From: Rutterford, Beth - E&E
Sent: 18 November 2021 12:47
To: Planning
Cc: Beth.Rutterford
Subject: OCC Public Rights of Way - Planning Response - 21/03759/F

Adderbury Footpath 5 runs through the proposed development site.

**SITE LAYOUT PLAN**

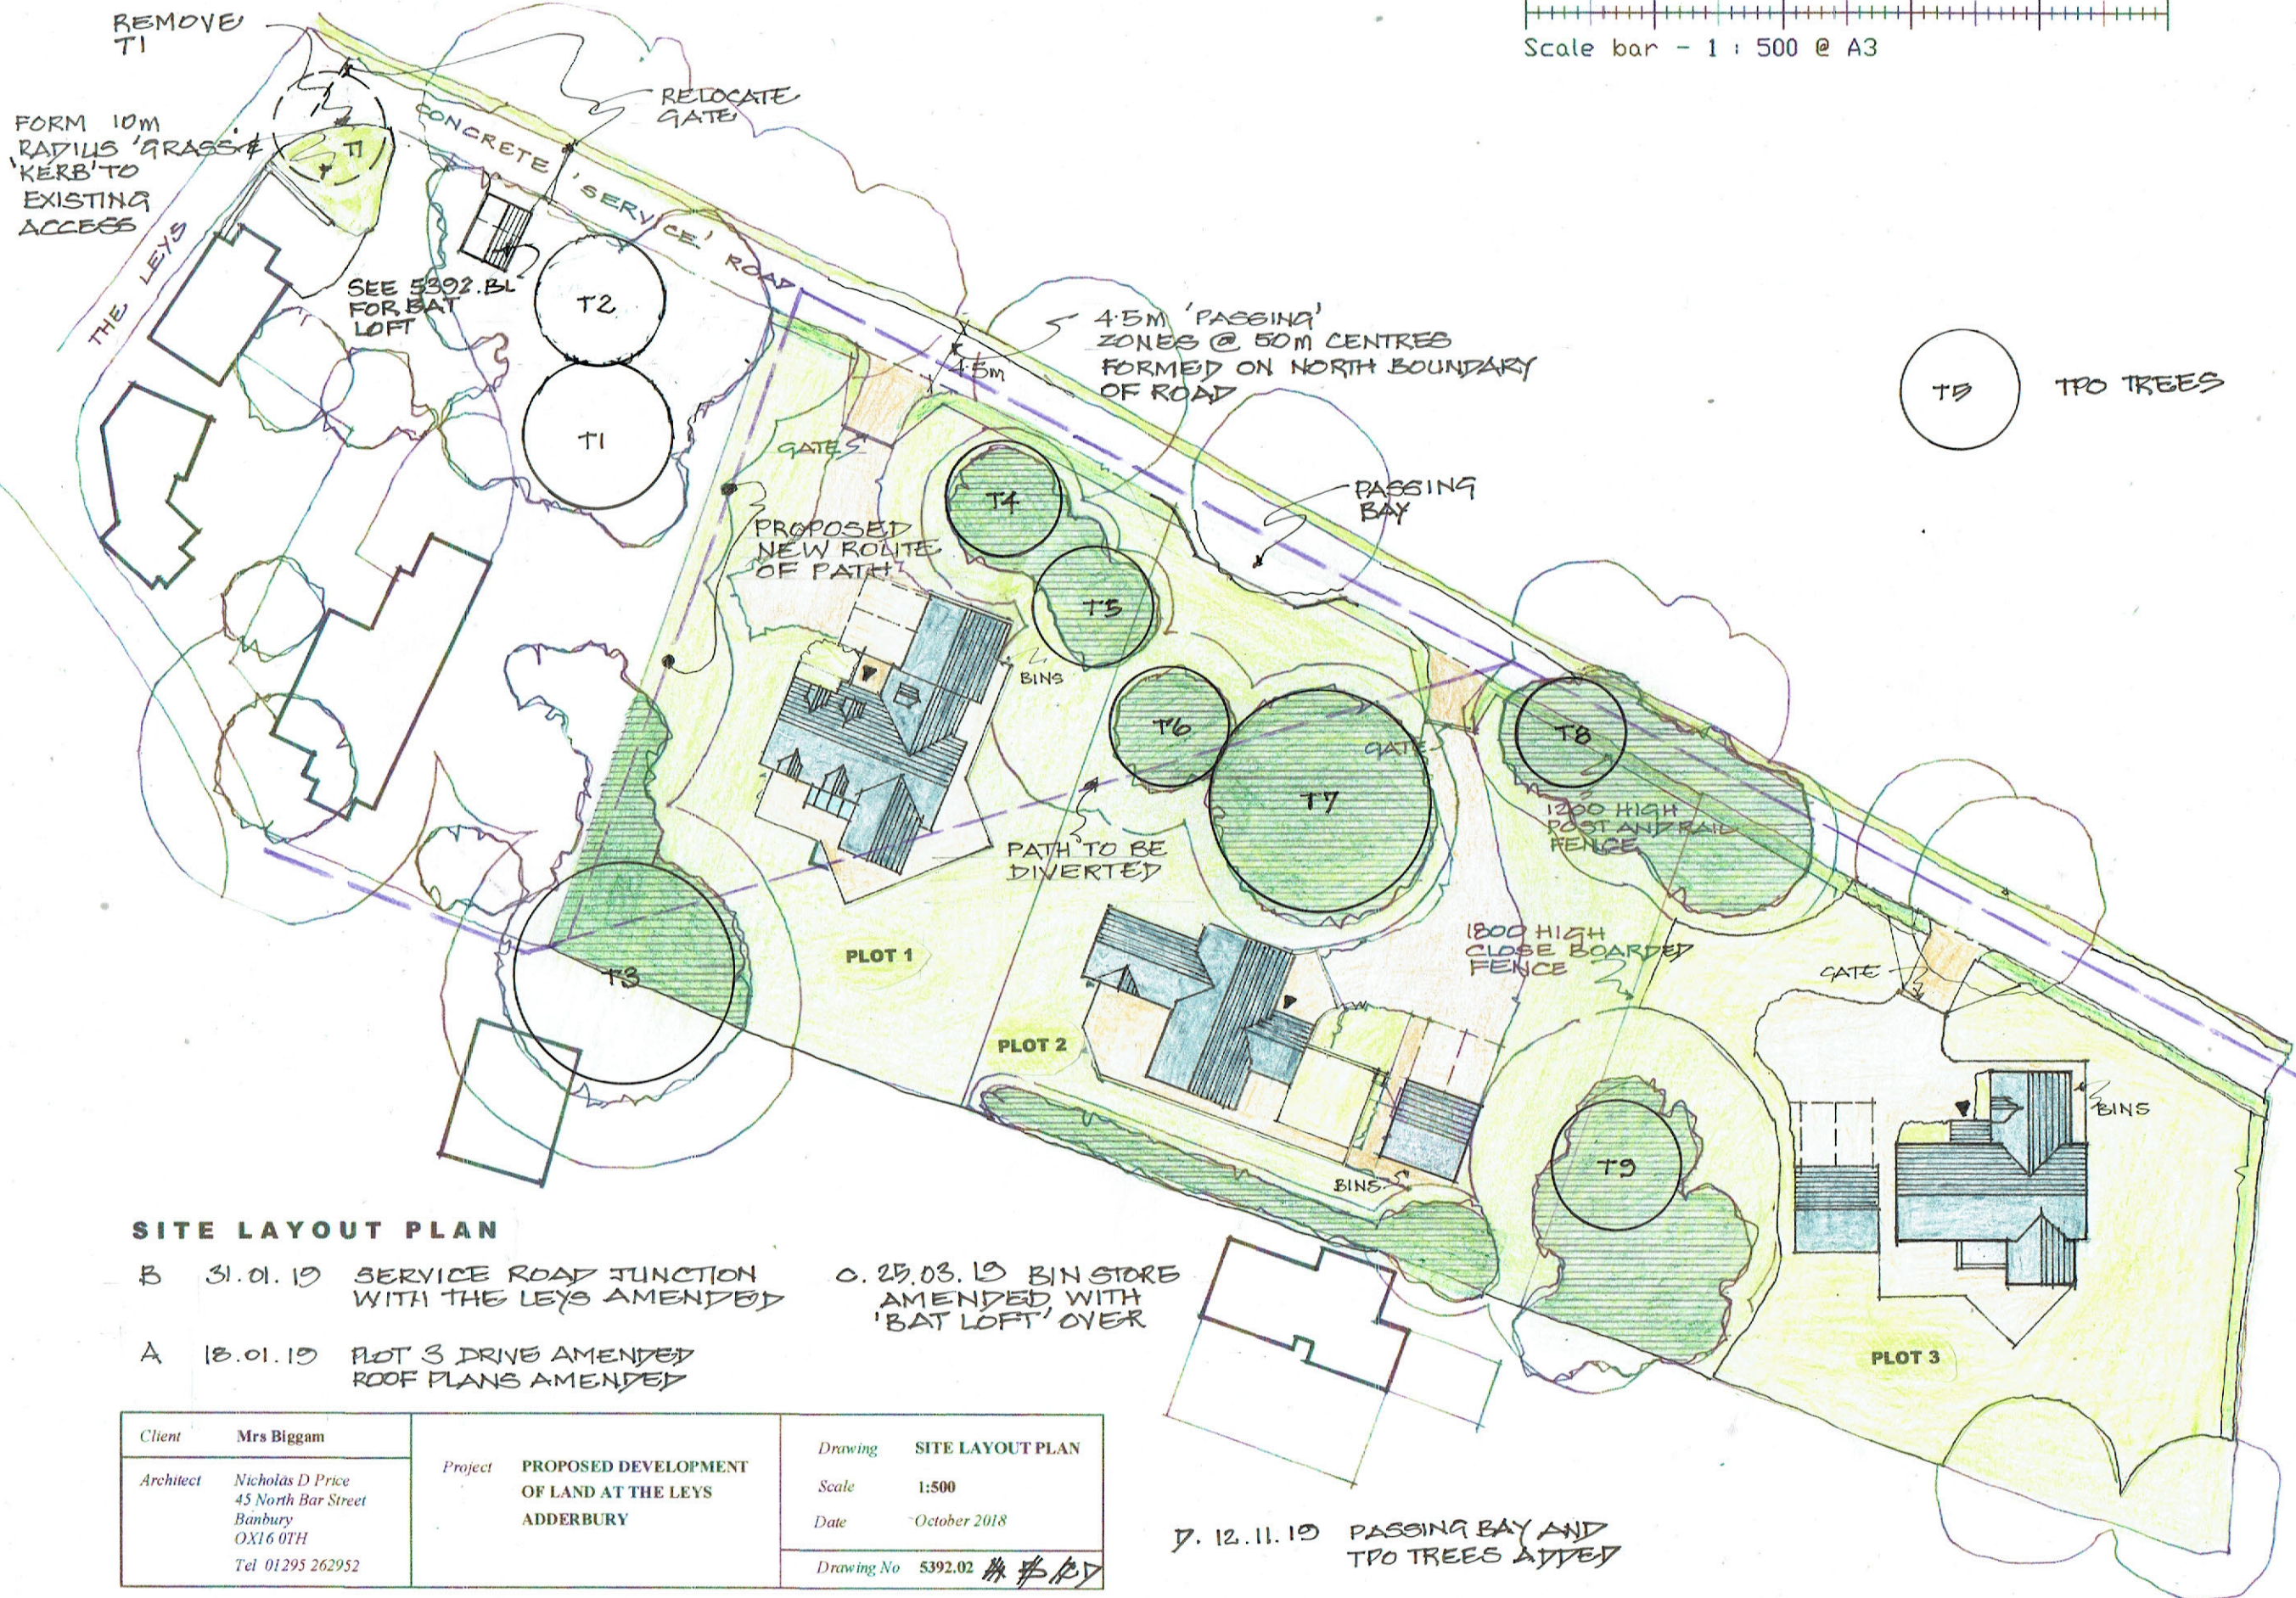
The application suggests that the applicant is intending to divert the footpath. The applicant must be aware that a diversion CANNOT be guaranteed success and therefore the current Definitive Line of the footpath must remain open and available until the diversion of the footpath has been successful. **If the applicant cannot secure a diversion then this development would have significant negative impact on the Public Footpath and therefore should be a condition on the planning permission.**

The new diverted footpath must be of sufficient width, at least 3m and should have not gates or other structures.
